Response to Planning Application

From: Arun District Council Greenspace
Date: 03 March 2021

Application ref: A/3/21/PL

Description: Erection of a 74-bed care home (C2 residential institution) with car parking, landscaped gardens & access from Roundstone Lane. (resubmission following A/9/19/PL). This site is in CIL Zone 2 (Zero Rated) as other development.

Drawing Site Layout
General Arrangement

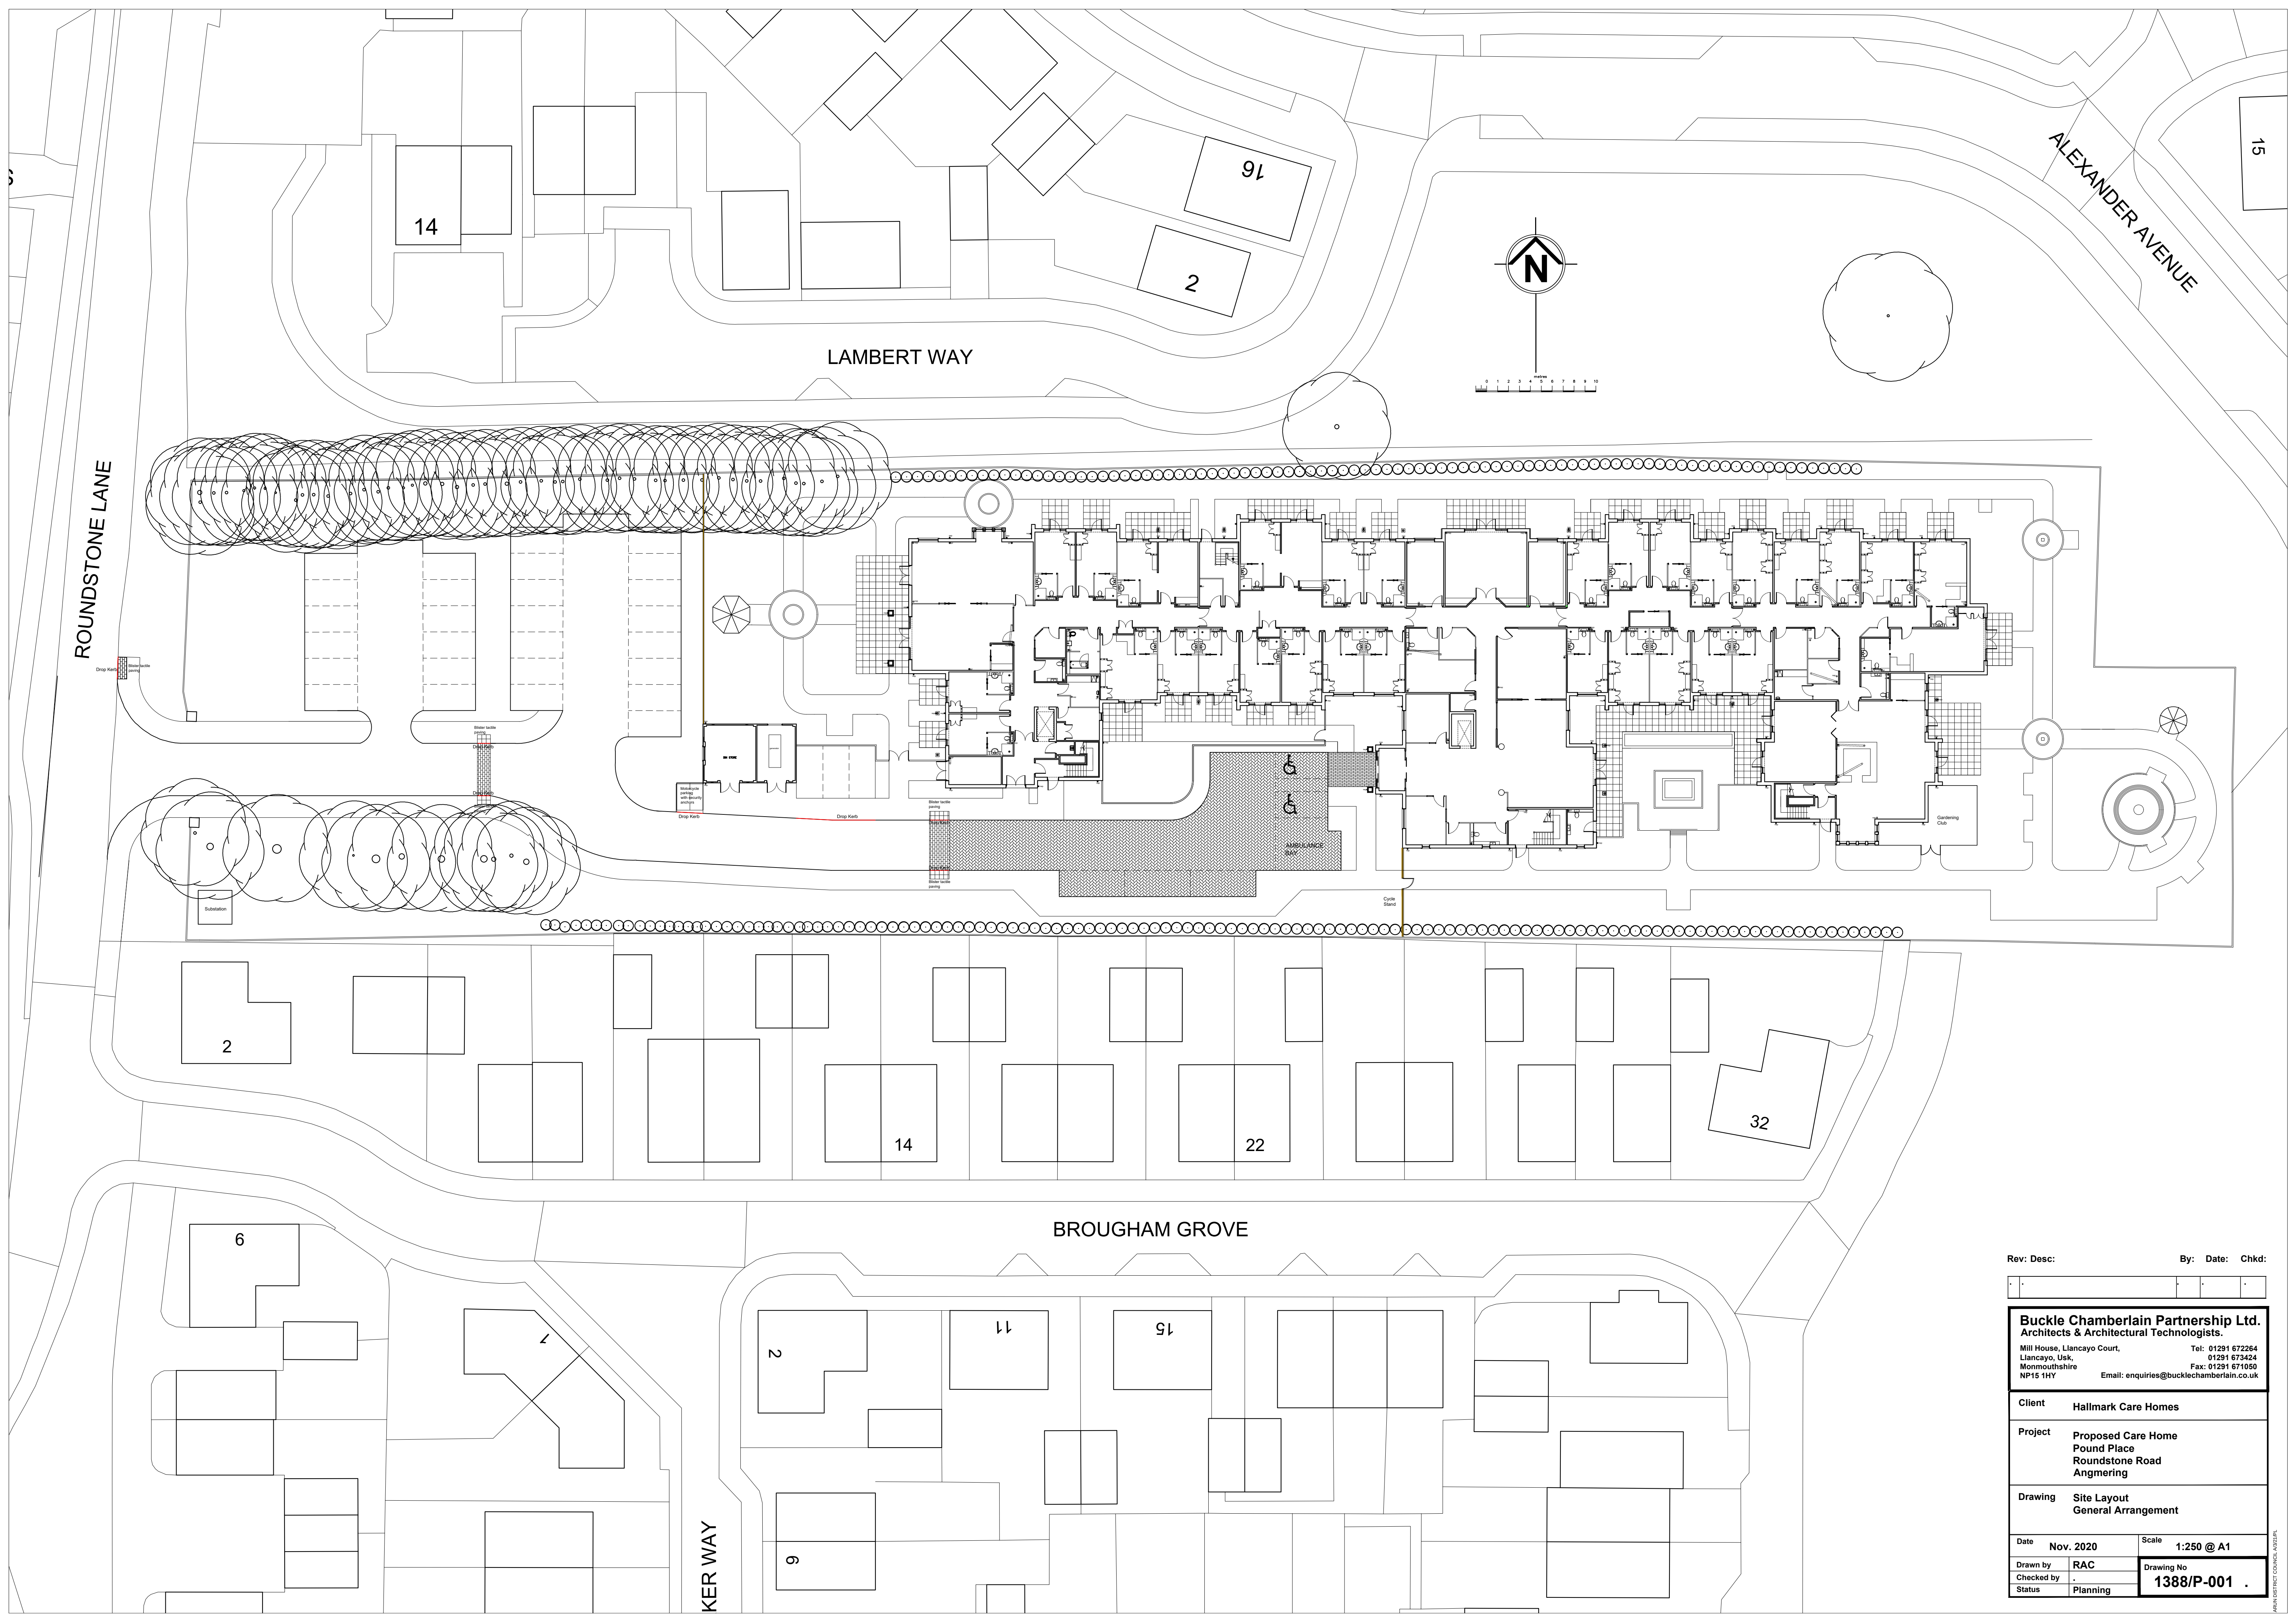
The proposed site is screened extensively to all sides and of note are the TPO'd trees forming part of the established tree cover. Significant tree and vegetation removal has been indicated to facilitate the proposals within the indicative plans submitted. If tree removal were to be considered to facilitate this development in relation to its setting and the adjoining dwellings then a landscape scheme will need to be detailed, be appropriate for setting, provide mitigation where appropriate, provide screening to the new building, but will also provide a scheme which will enhance and provide a garden setting for the use of the proposed residents, their visitors and care home staff. Any scheme must take into consideration the needs of the development along with the wider viewpoints. Consideration should be given to species choice for these locations. The indicative drawings indicate some landscape consideration, this would need to be detailed with consideration for creating outdoor open space for the users as well as the location of these proposals within an established garden setting. The need for the establishment of quality, safe and stimulating outdoor space to be provided should be key to the design and executed to a high standard.

A full landscape scheme will need to be submitted for approval, or conditioned as part of any approval; detailing species choice, position, densities and size at time of planting. This should be plotted in plan and list form and in relation to the trees and vegetation to be retained so that a clear picture of the proposals can be seen. These details are required to ensure that appropriate mitigation is provided, maintaining and uncompromising the setting and ensuring that the proposals fit within the area of neighbouring properties. These will need to incorporate screening as required, adding to and enhancing the setting, benefiting the potential of the proposed developments usage.

Proposed planting would need to be sufficient in height with a mix of both tree and shrub species. Any screening proposed will need to provide a good mix of native species which when planted should establish quickly to form a balanced and appropriate planting scheme, which is sympathetic to and doesn't compromise the location. This would be realised as it matures and the effects on the landscape of the development will diminish over time. The proposals could provide the opportunity to enhance existing planting and to secure on-going management of all structural vegetation within and to the periphery of the site.

Any considered tree removal from this site should be agreed with Arun District Councils Tree Officer. Root protection Areas (RPA) should extend into the development site and to those in neighbouring land. Before construction, a tree protection scheme must be in place for any retained trees including trees whose root protection areas fall within the construction zone from neighbouring land. This should be in accordance with BS 5837:2012 'Trees in relation to construction' Any removed trees should be mitigated for allowing for inclusion of native species for biodiversity purposes and fitting to this setting.

I would recommend **no landscape objection** to the proposals, subject to the submission for approval of a detailed landscape scheme as above.
